Permit Inspections Harnett County

Permit Number: BRES2312-0208

Description: total 12x30 additon =12x12 Sitting room 12x18 living room

Site Address: **18 PINERIDGE CV**

**CRAWLSPACE FOUNDATION**

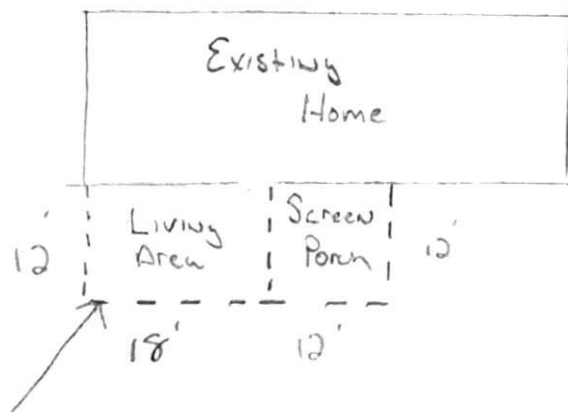
| SEQ ID | SCHEDULED DATE | COMPLETED DATE | TYPE | INSPECTOR | RESULT | REMARKS |
|--|----------------|----------------|--------------------|-----------------|-------------|---------|
| Notes: No answer at door. Inspectors will not go into fenced backyards. Have approved plans onsite with Gate open. Must have 2 #4 rebar dowels into existing footings at each tie in. Need pour depth markers. Washed in soils must be removed. Sewer will need to be sleeved. Unable to complete inspection. | | | | | | |

( 10" opening Detail )

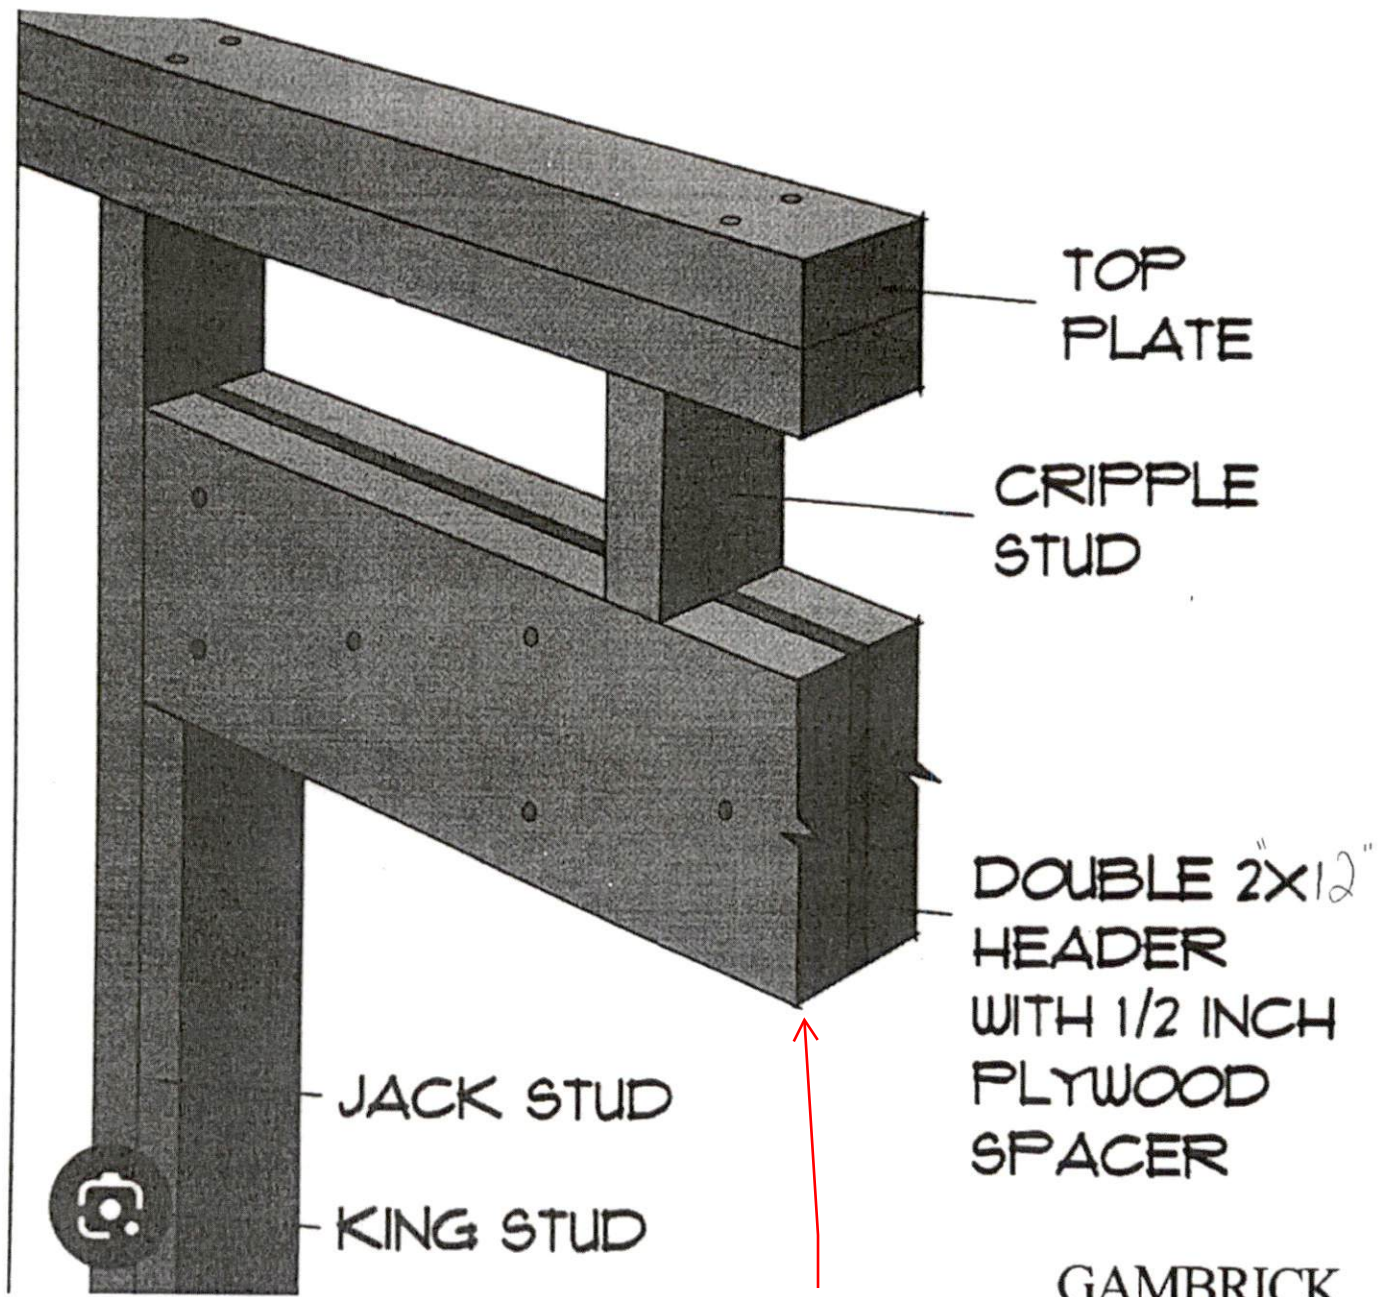
Notes:
1/ all window rating decals have been removed 2/ missing LVL at 10' opening. 3/ roof slope min 3 - 12 verity required underlayment. 4/ need header over existing crawl opening. Ok to insulate
1/ all window rating decals have been removed 2/ missing LVL at 10' opening. 3/ roof slope min 3 - 12 verity required underlayment. 4/ need header over existing crawl opening. Ok to insulate
